**Planning Applications, Ribble Valley District
D3-11-0444 Unit 6, Salthill Industrial Estate, Lincoln Way, Clitheroe**

I am recommending refusal of this application on highway safety grounds.

PLAN 2.

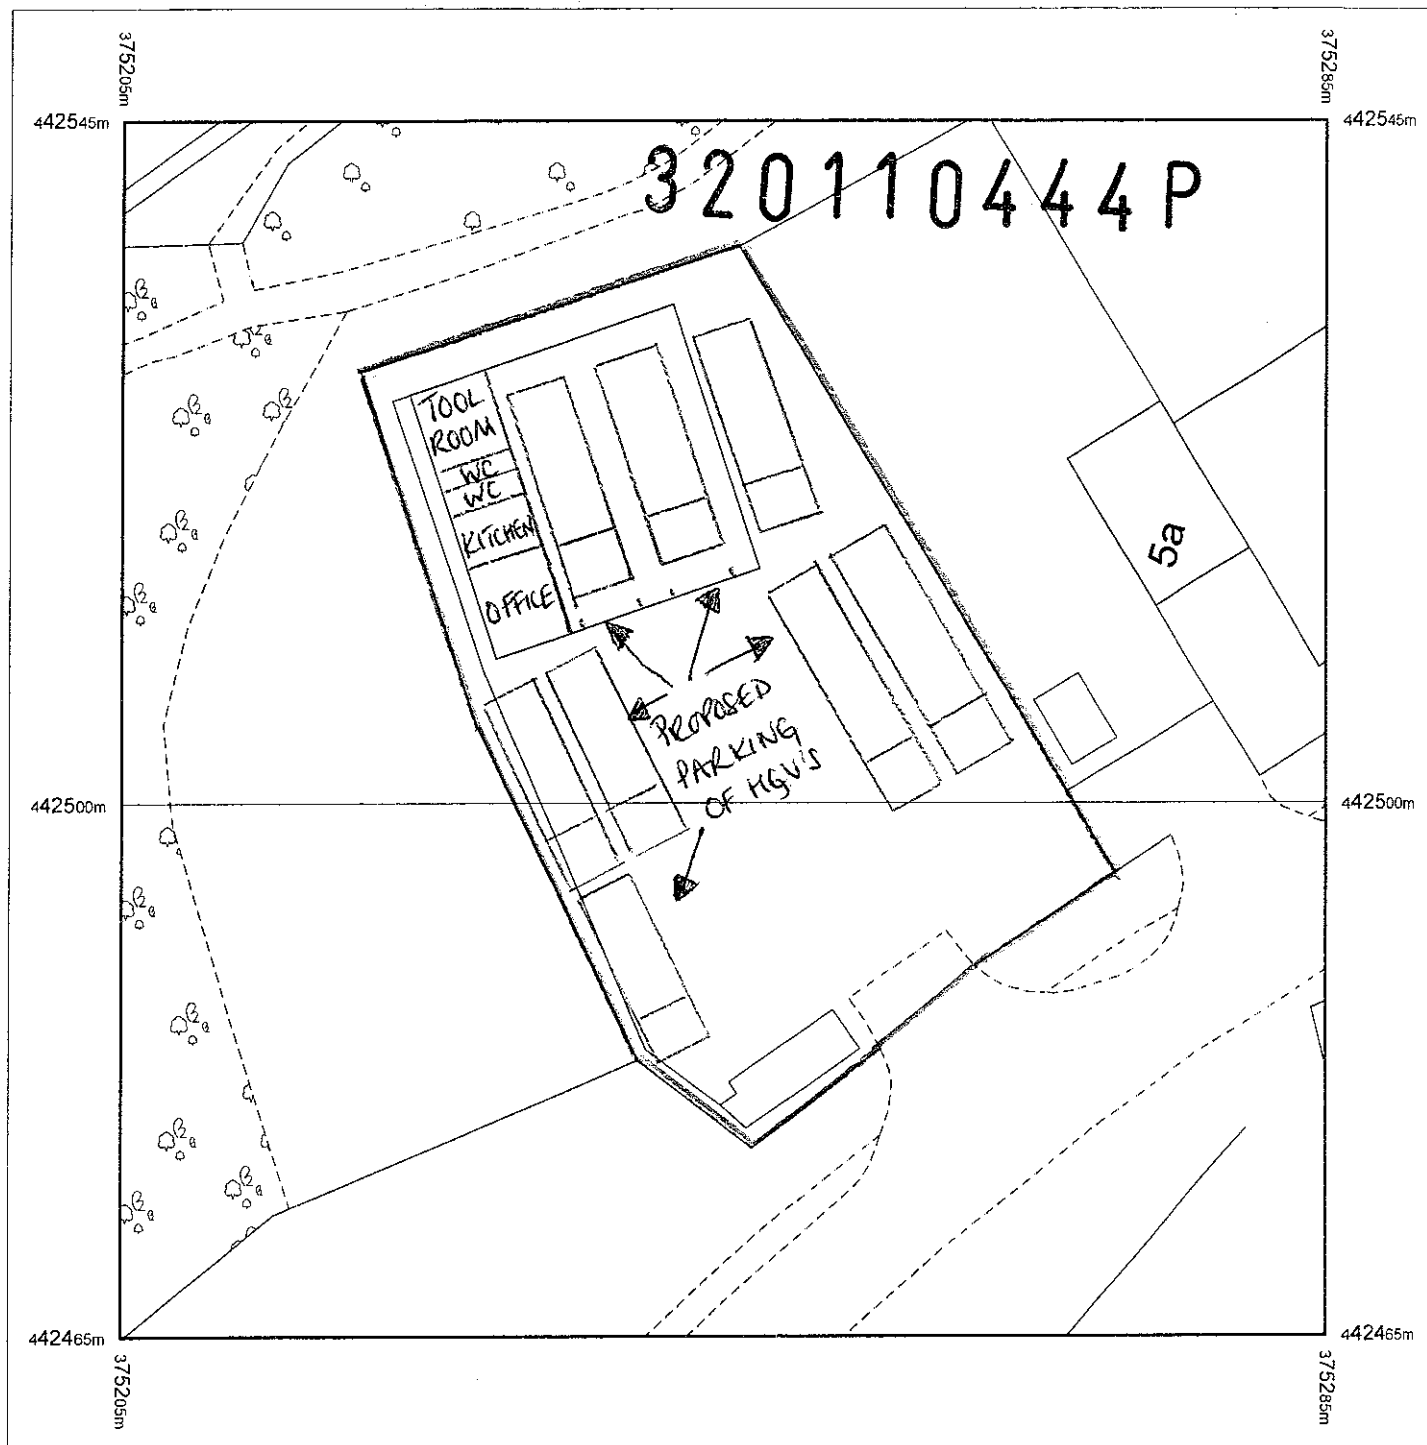
The application aims to accommodate 6 larger vehicles and parking for 8 staff vehicles within the development site. The plan provided in support of the application indicates parking for the larger vehicles within the available curtilage but does not identify the manoeuvring space required to achieve this parking arrangement.

In order to operate safely from this location it is imperative that all vehicles utilizing the site can enter and exit in a forward gear and the site shall be laid out so that all appropriate movements can be accommodated. The necessary parking provisions and the agreed vehicular turning spaces must be laid out and available for use before the development is brought into use. This is a necessary requirement to insure that no vehicles are reversing to and from the highway where they could be a hazard to other road users.

In addition, the staff parking spaces must be shown on the site plan so that permanently marked spaces can be identified as part of any future consent and that the safe operation of the proposed layout can be assessed. The present plans do not give any indication of the location or operation of the staff parking area.

I would welcome revised plans that aimed to address the above comments. These should include clearly defined areas of operation within the site and details of swept path analysis to confirm that larger vehicles can enter and exit Unit 6 in a forward gear and manoeuvre safely within the site.
